METROLINK RAILWAY ORDER – COMMENTARY ON TII RESPONSES – MARCH 2024

Author – Peter Twamley FRIAI

Date – 25 March 2024

ST. STEPHENS GREEN STATION

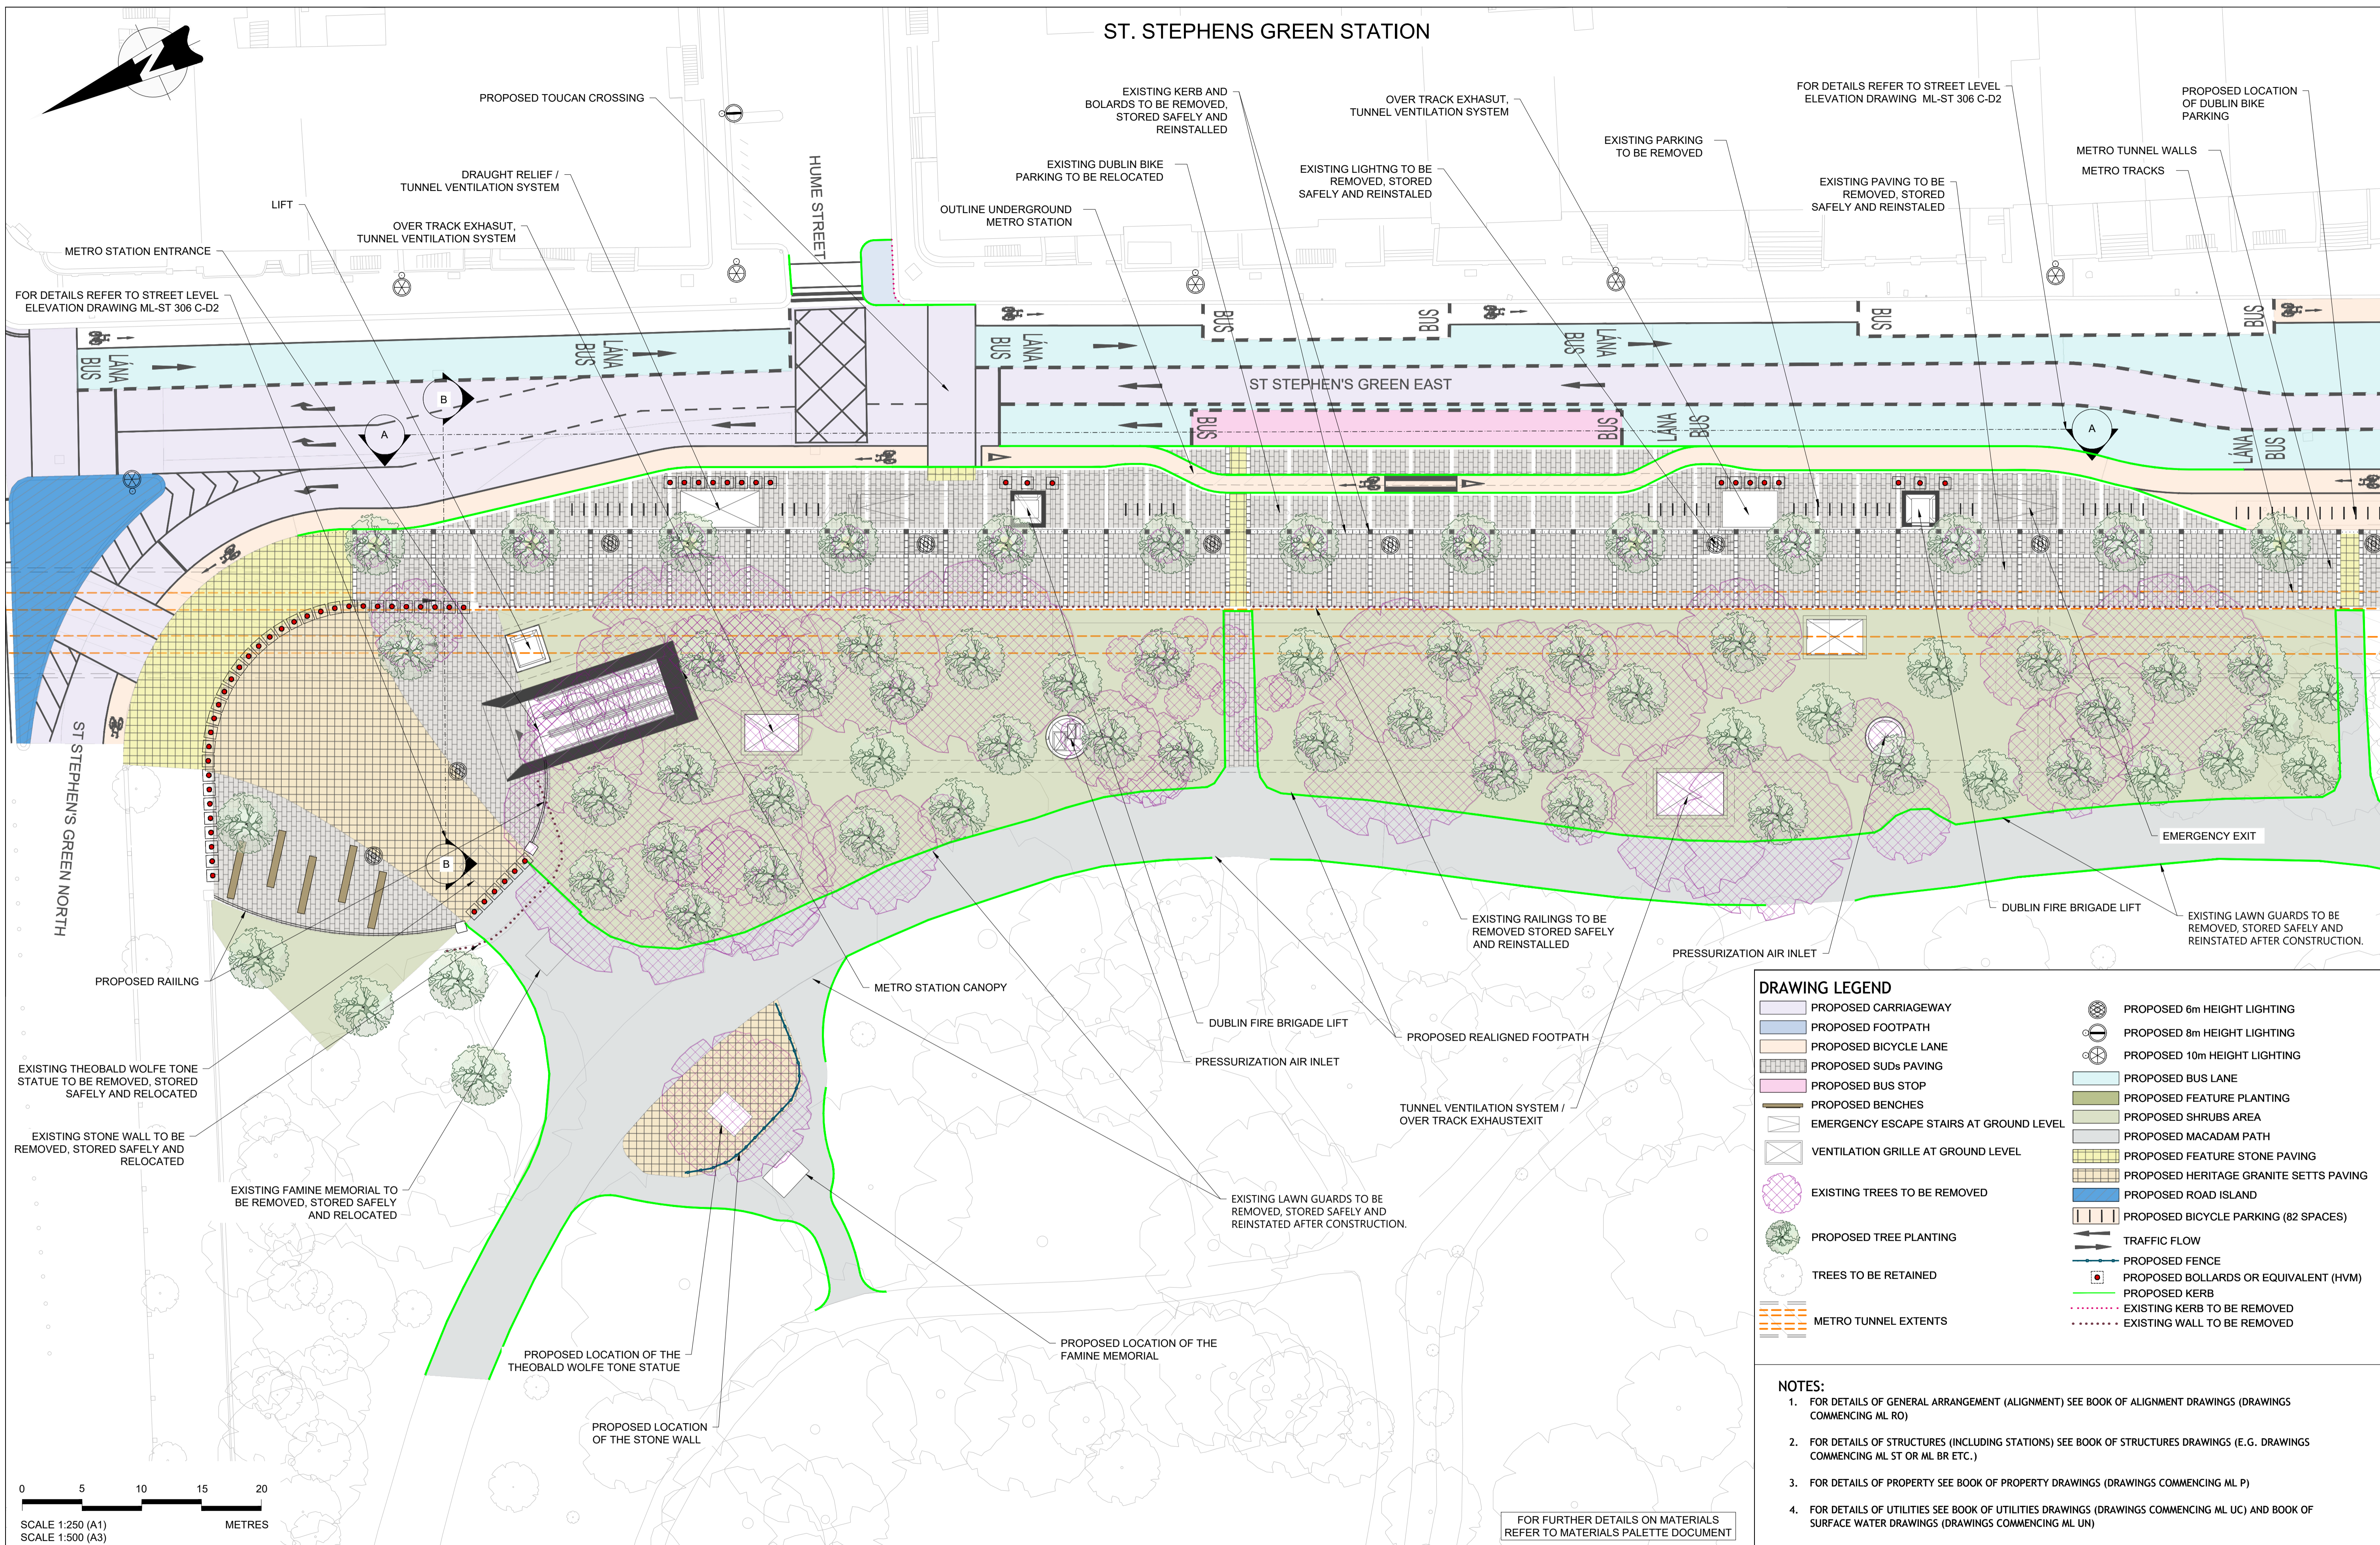
4. THE LOCATION OF A STATION AT SSG EAST FAILS TO OPTIMISE THE INTERCHANGE POTENTIAL WITH THE LUAS GREEN LINE AND A FUTURE DART UNDERGROUND STATION

I am concerned that the Railway Order route design does not seriously and adequately take account of the proposed Interconnector / Dart Underground / Dart+ Tunnel only allowing for a flip-flop east or west location on St Stephen’s Green.

The DART+ Tunnel Route Options and Feasibility Final Report of October 2021 by the National Transport Authority (page 79 - section **5.2.4.3.3 - St Stephens Green Station**) confirms that the previous DART Underground station design has been simply mirrored to suit a proposed SSG East Metrolink station.

A Metrolink station could be located on the west side of SSG interconnected with the Luas Green line and a future DART Underground station in a major interchange opportunity.

In terms of a SSG West location option and the protection of SSG itself, I would like to suggest to this hearing (and Dublin City Council’s attention) the possibility of an access location within a potentially redeveloped SSG Shopping Centre – cross-referencing in a sense the proposed use of the Carlton Cinema site in O’Connell Street.

In terms of such a major interchange I would also point out that there is adequate space for the SSG Luas stop to move south to the other end of SSG West closer to Cuffe Street on either a permanent basis or on a temporary basis during Metrolink construction.

Client	TII NTA	Project	METROLINK	Drawing Title	METROLINK - STRUCTURES CHARLEMONT STATION PROPOSED STREET LEVEL DESIGN	Drawing Status	S0
Consultant	JACOBS IDOM	Drawing N°	ML1-JAI-SRD-ROUT_XX-DR-Z-02090	Plan Drawing N°	ML-ST 307 O-A1		
		Scales Original Size A1	1:250			Sheet	1 of 6

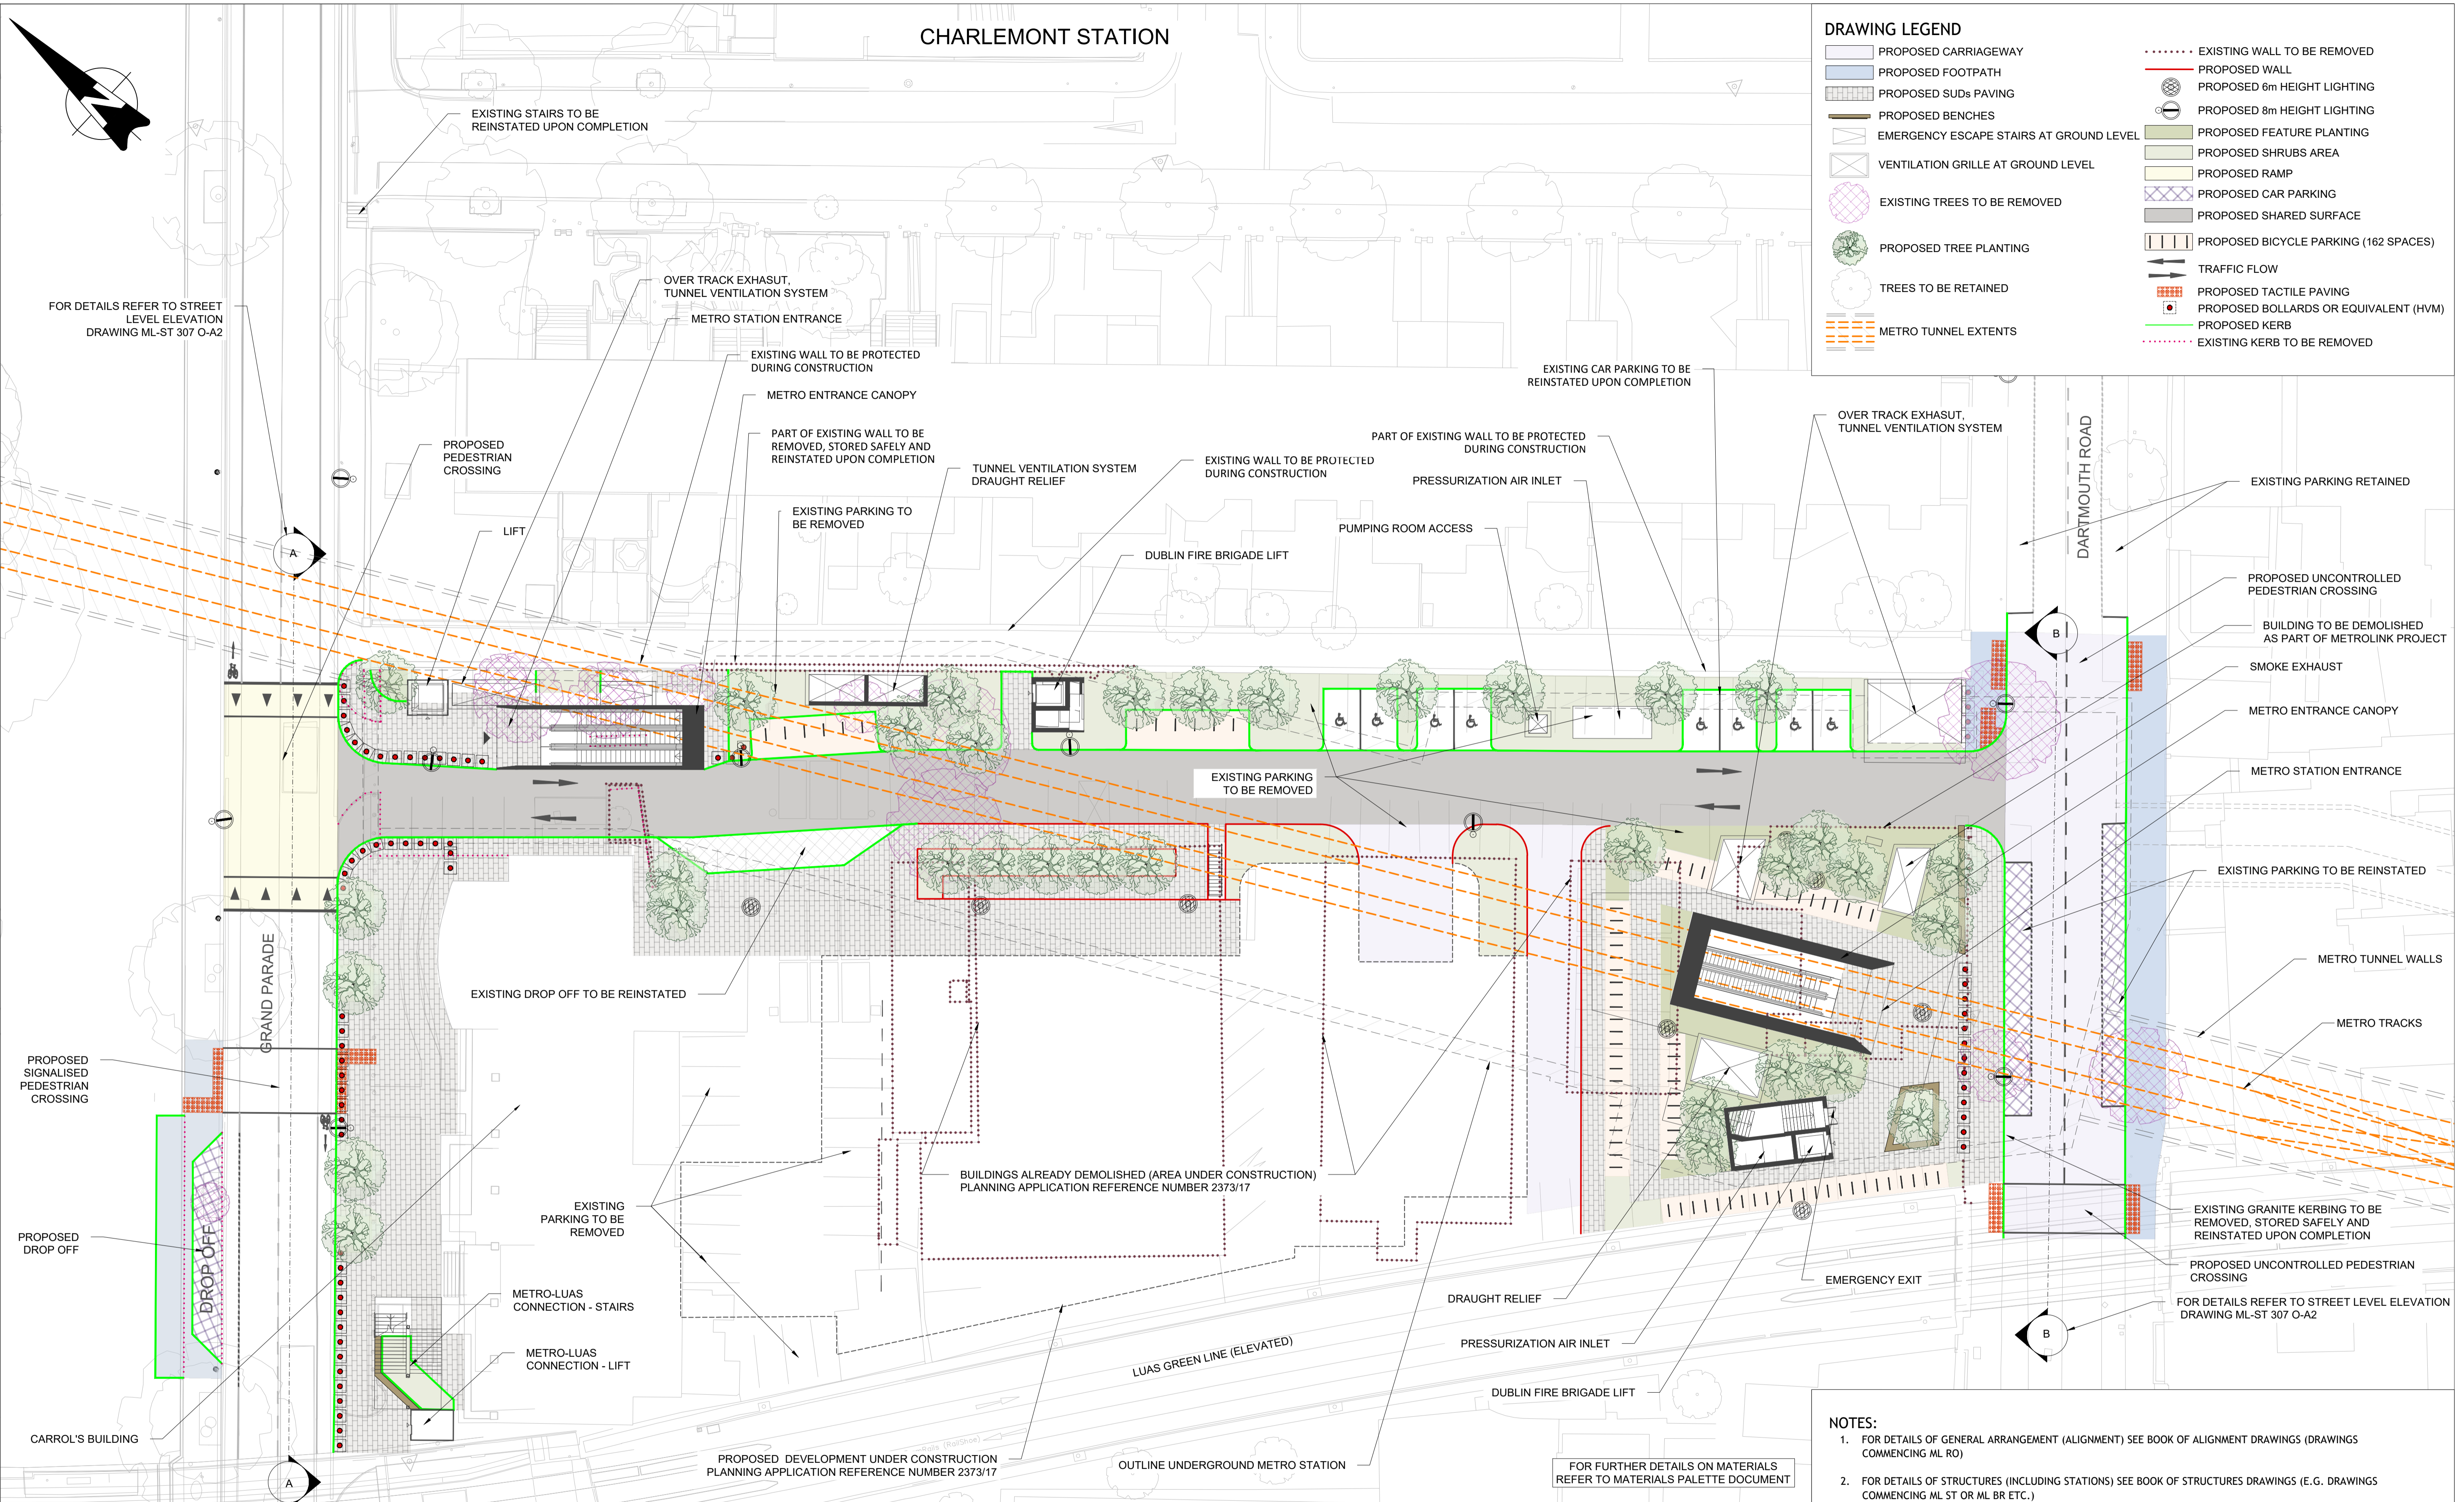
3. THE IMPACT AND DISTURBANCE OF A MULTI-LEVEL INTERCHANGE STATION AT CHARLEMONT IS BOTH UNWARRANTED AND UNNECESSARY

The Charlemont interchange is a complicated multi-level design due to the need to travel below the 4m diameter Grand Canal Drainage Tunnel – ref Gerry Duggan’s earlier submission – and then connect with the elevated Luas Green Line across the Grand Canal – a very significant height separation.

The proposed staircase and lift connection to be placed directly in front of the façade of the Carroll’s Building is an affront to this iconic Listed Building - Ref no 3280 on the Dublin City Council Schedule of Protected Structures
